Y/52/22/DOC

Stakers Farm North End Road Yapton BN18 0DU

Approval of details reserved by condition imposed under Y/105/19/PL relating to conditions 3-flint flooring and stall dividers, timber ceiling details, 4-flint flooring details, 5-surface water drainage and 9-electric vehicle charging.

DRAWING TITLE
PROPOSED SITE LAYOUT

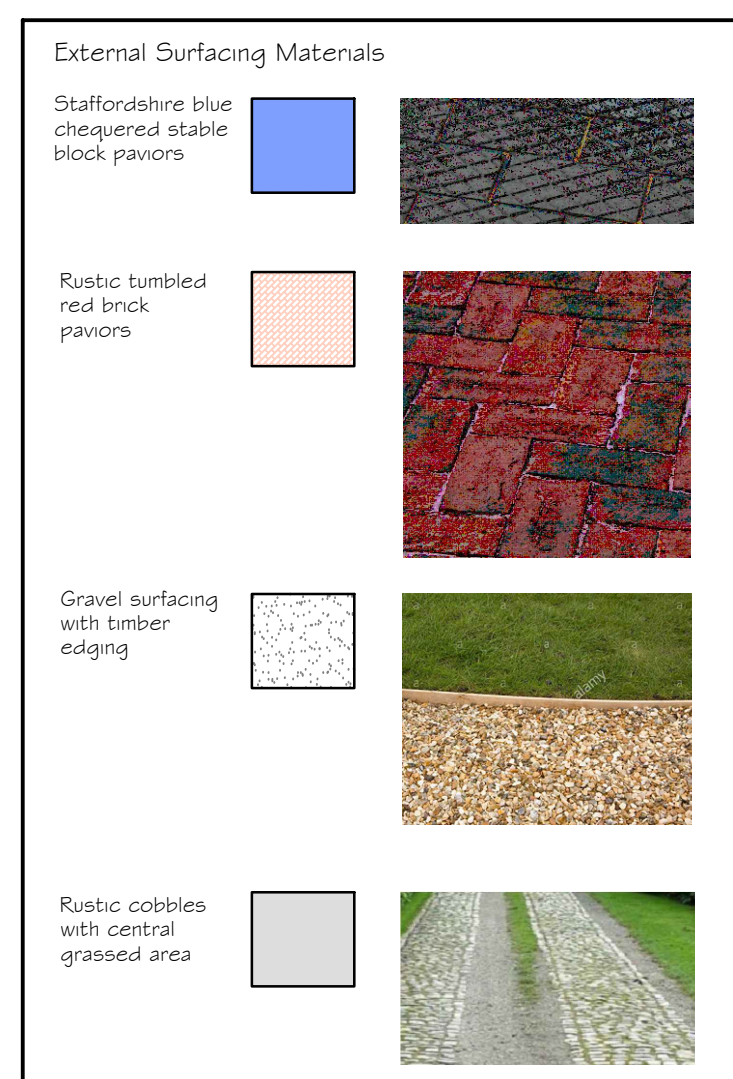
At present a number of the plans supplied DOC application (such as for the site layout and the barn garage) are those supplied for the current application and do not relate to application identified in the description i.e. Y/105/19/PL. There have been a number of changes in the proposals since the original approval, and it is not possible to use the current plans to assess the details required of the previous application.
